From: Amanda Scholes on behalf of Planning.Responses
Sent: 08 February 2018 08:35
To: Planning Scanning
Subject: FW: CM/30/17/L & CM/29/17/HH - The Diary, Brookpit Lane, Climping.

From: Clare Dales
Sent: 30 January 2018 12:08
To: Ross Leal
Subject: RE: CM/30/17/L & CM/29/17/HH - The Diary, Brookpit Lane, Climping.

Job Title	The Dairy Brookpit Lane, Climping		
Client	Antoinette Wilks		
Drawing Name	Plan and Elevations Proposed		
Drawing Status	Planning		
Drawn by	AF	Date	Aug 17
Checked by		Date	
Drawing Scale	1:100 at A2		
Drawing No	171128/	Status	02
		Revision

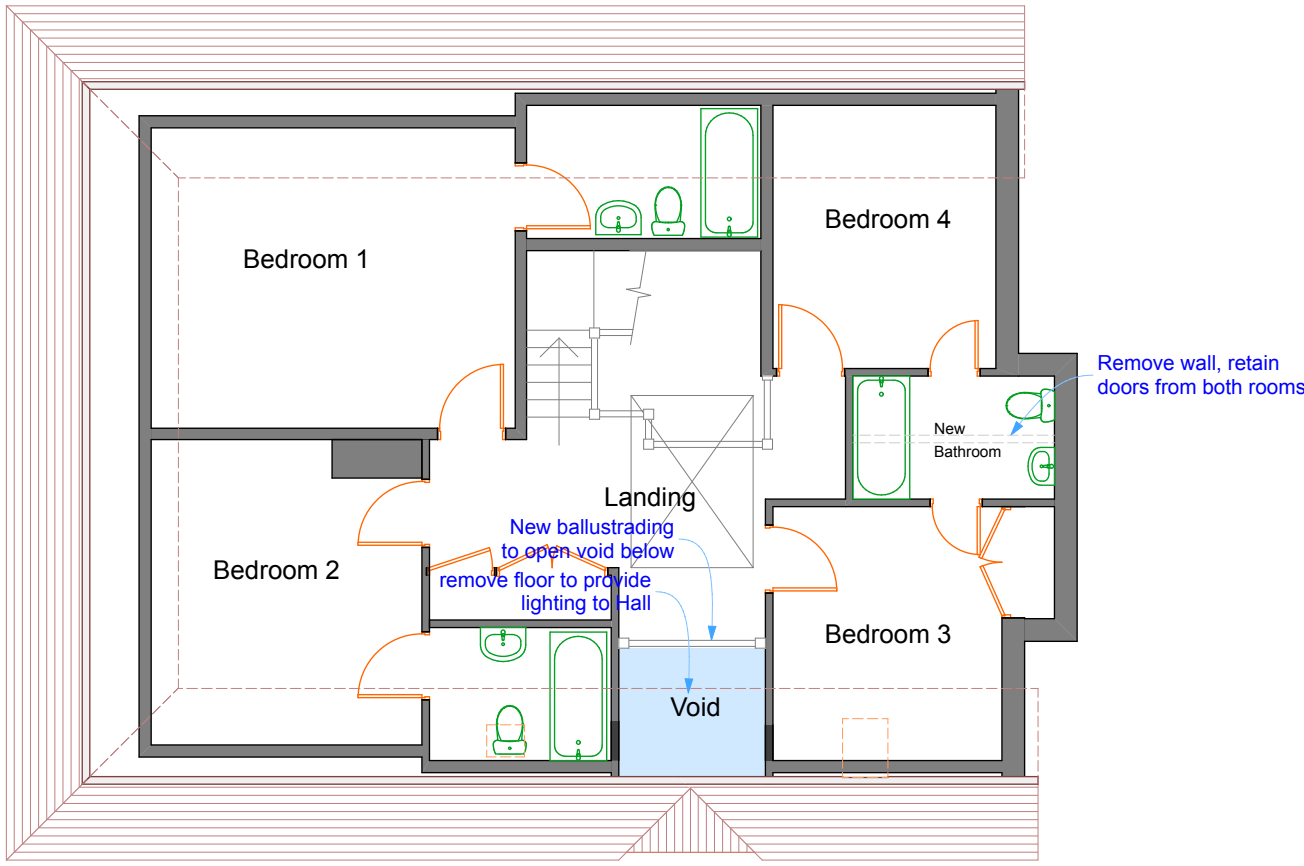
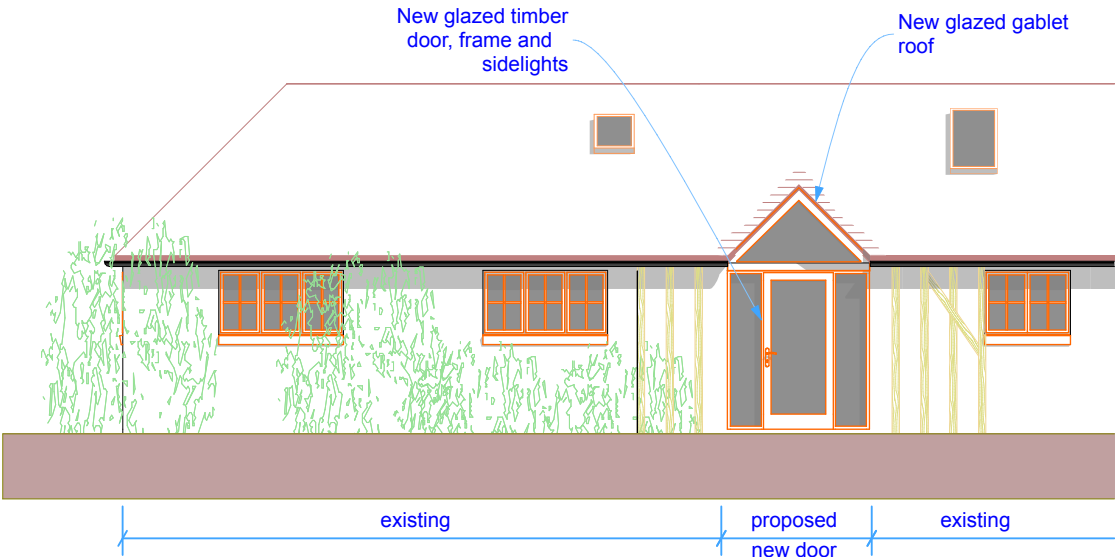
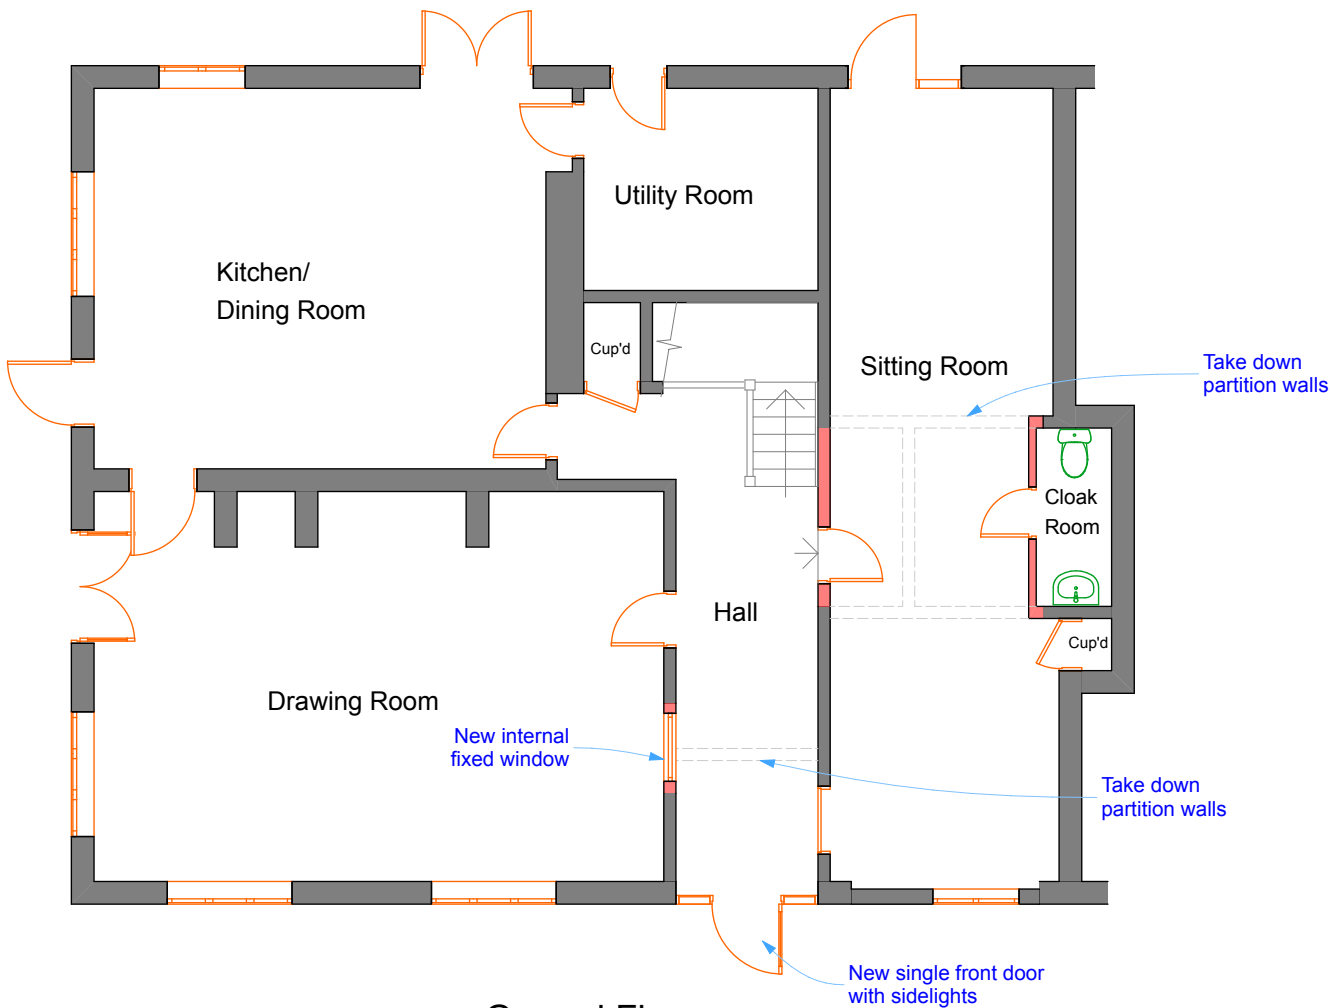
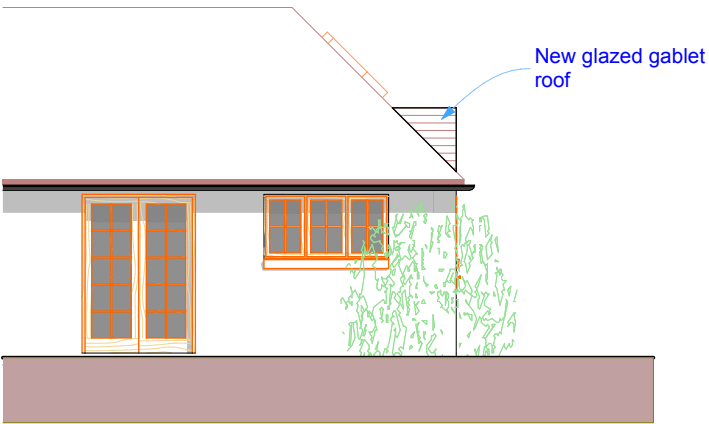
I visited the site today. It appears, from what the owner tells me, that the Dairy was the subject of fire damage, and underwent an extensive re-build in the late 1980's. From a visual inspection, it appears that a number of original walls remain, which I would recommend are not breached. The internal proposals, are in the main acceptable (with one exception of breaching the hall wall to make a window), the proposal to open the landing is acceptable, as it is clearly modern rough, stained pine. I also object to the overall design of the porch as it is overly glazed and interrupts the roof(eaves) line and is out of keeping with the outward agricultural nature of the dwelling.
